Application: SSI 7485

I write regarding the proposed modification to M4-M5 Link, Mod 2 The Crescent overpass and changes to pedestrian infrastructure in North Annandale, Rozelle and Rozelle Bay Foreshore area. *I object to the car overpass and to the relocation of the GreenLink and*
I request RMS work with the community to explore alternate design options to the proposed new car overpass design and the changed pedestrian and cyclist links. I am seeking the reinstatement of the safe, direct access from the approved EIS GreenLink to create a continuous green open space connection from the Rozelle Rail yards and Annandale to the foreshore. The GreenLink was more than just a walk way - it put people central to the design, maximising safety, and providing much needed accessible open space for the community now and into the future Bays Precinct design.

Figure 4-2 Pedestrian and cyclist bridge infrastructure options

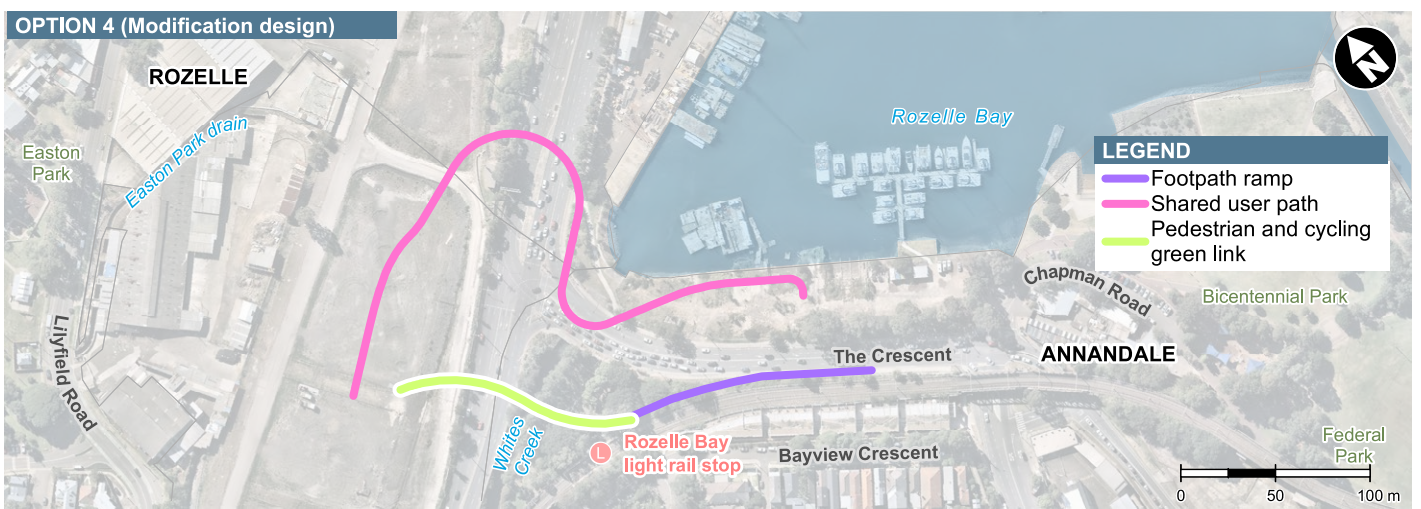
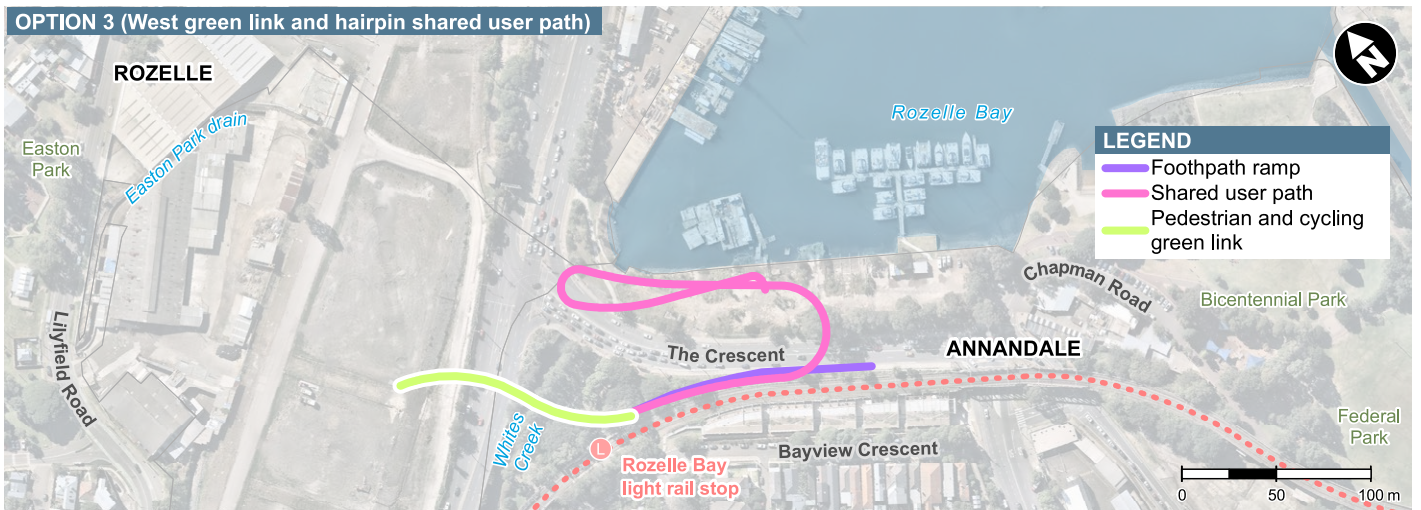
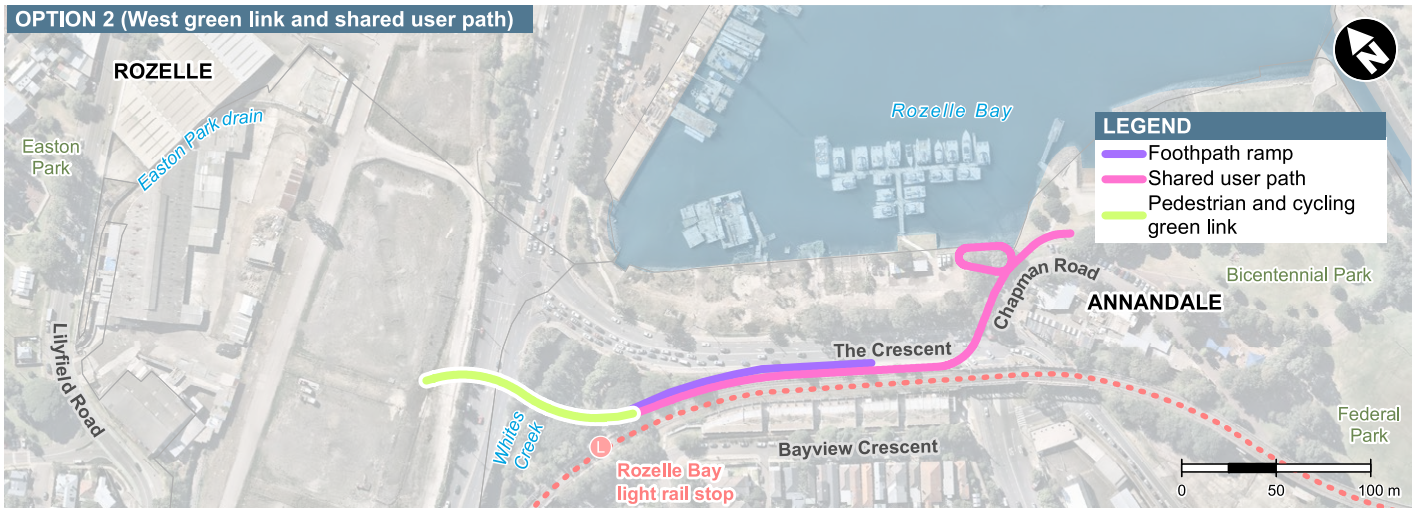
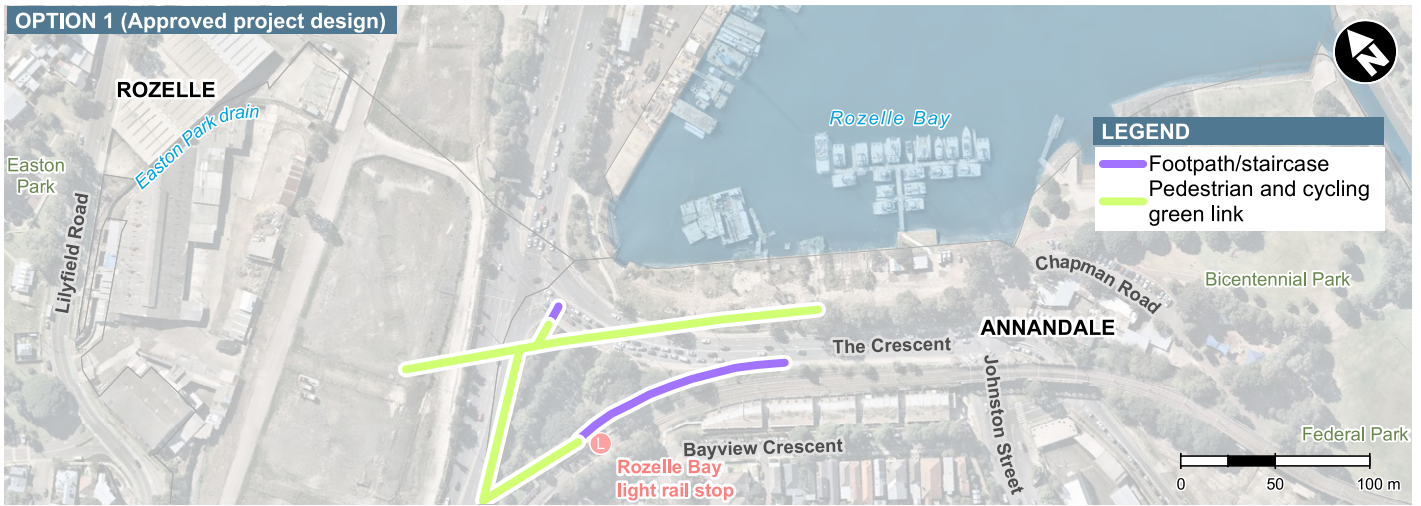
- The significantly reduced safety and increased risk for pedestrians and cyclists with removed access over The Crescent to Bicentennial Park and the increased traffic along Johnson Street.
- Being required to cross five sets of pedestrian lights at The Crescent as my option to reach the foreshore from Annandale or from Rozelle Bay light rail stop.
- Removal of direct active links to the foreshore, cutting the community off from the area and the proposed revitalisation of the entire Bays Precinct, including linking the Light Rail and Bus stops to a Ferry wharf and Metro station.
- Urban and landscape design that is being built before a finalised Masterplan for the area.
- Traffic changes that limit movements around the suburb and create further congestion in the local streets of Annandale, Forest Lodge, Glebe, Lilyfield and Rozelle with no planning to deal with these.

- Reinstall the GreenLink connecting communities and green open space from Rozelle to Bicentennial Park
- Relocate and design pedestrian and cyclist connections that are continuous, safe and direct.
- Design the modification infrastructure and active links in response to the character of the suburbs, the location of the foreshore and its potential future development.
- Provide pedestrian and cyclist paths that maximise people safety and do not force them onto busier streets, unsafe concrete plazas and caged walkways.
- Integrate active and direct connections to all active transport – including the future Metro West and Foreshore Ferry Wharf

Figure 4-3 The Crescent, Johnston Street, Chapman Road intersection options

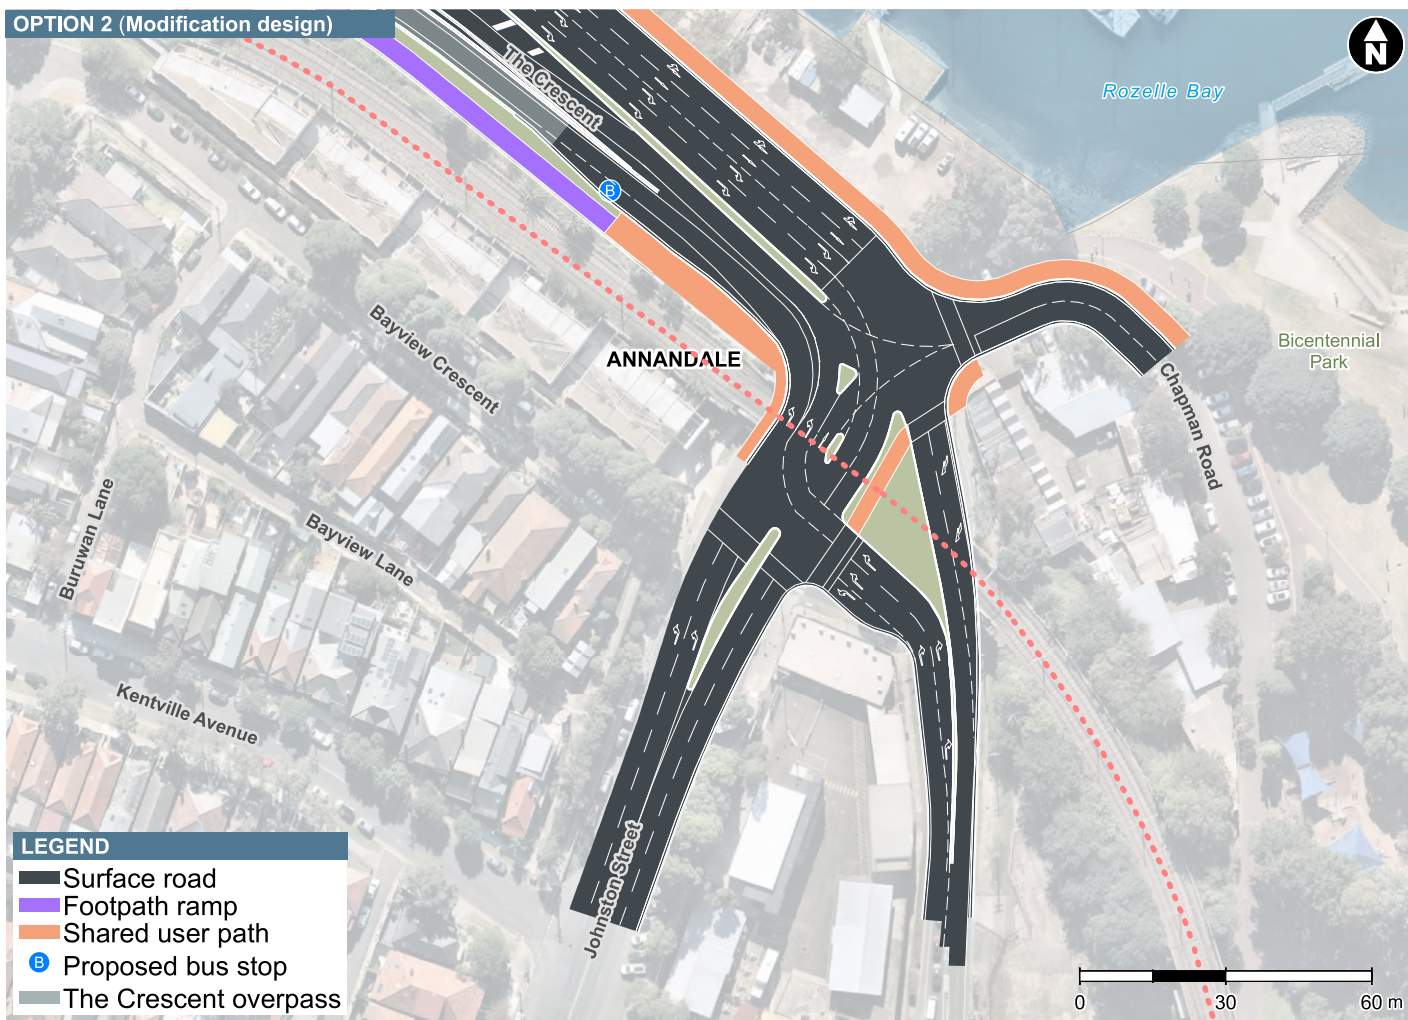
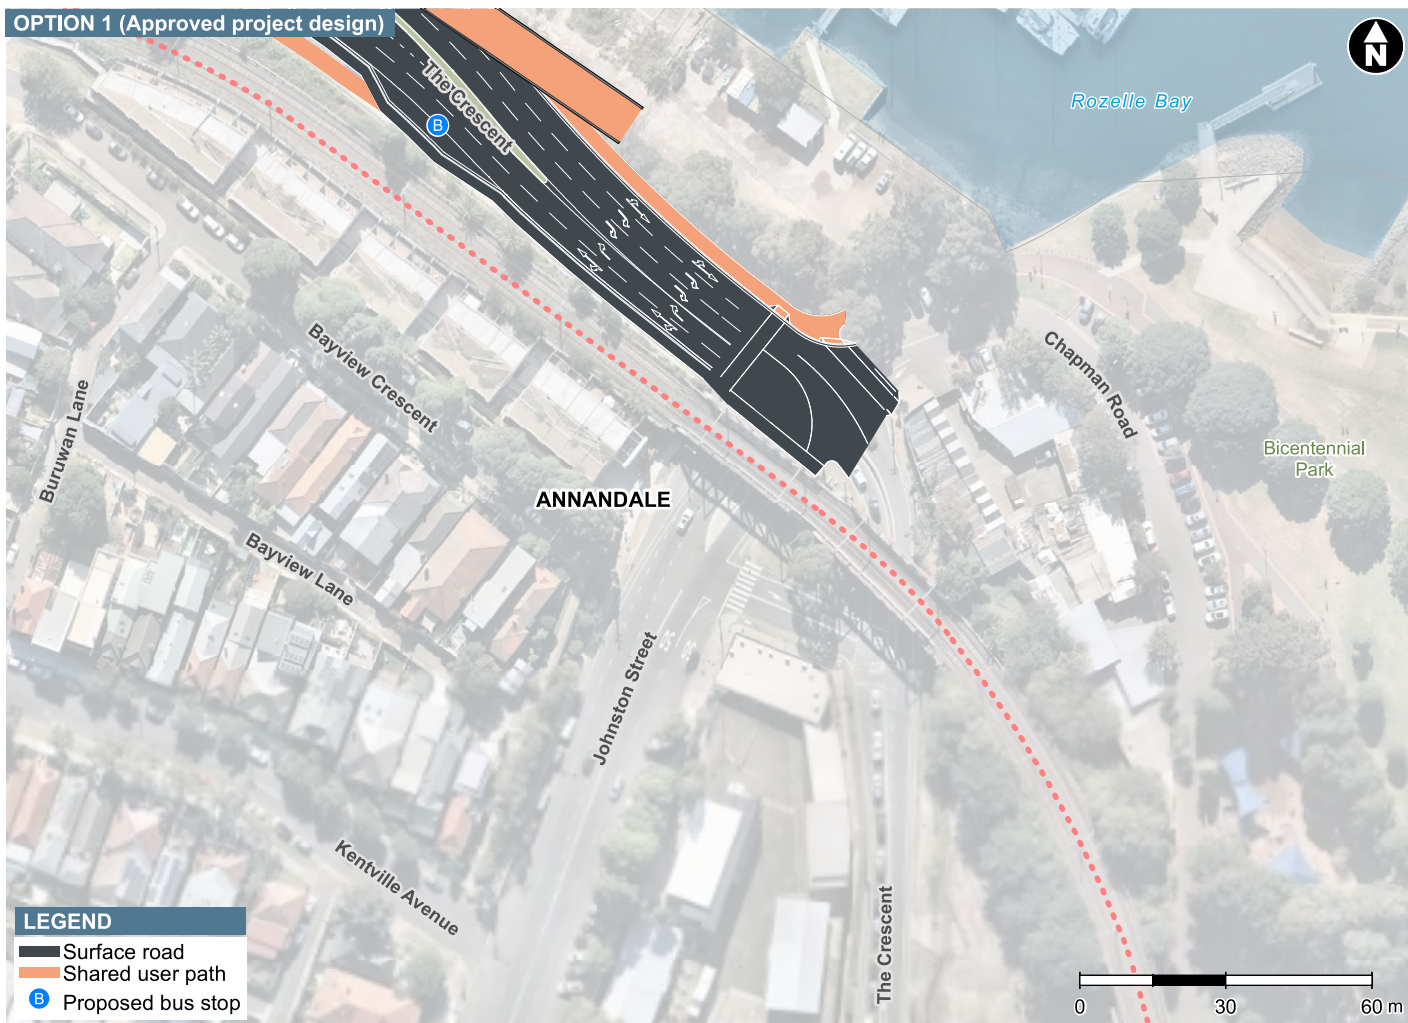
- *Inability to turn right from Johnston Street into the Crescent. ~~and~~ I use this route everyday to go from North Annandale to Glebe Point, Broadway, Sydney University and the Trans'ed.*
- *I also cross (with and without children) over the Crescent to Bicentennial Park several times everyday and am extremely concerned with the safety implications of the modification.*

maintain the right turn from Johnston Street into the Crescent (with improved safety provisions).
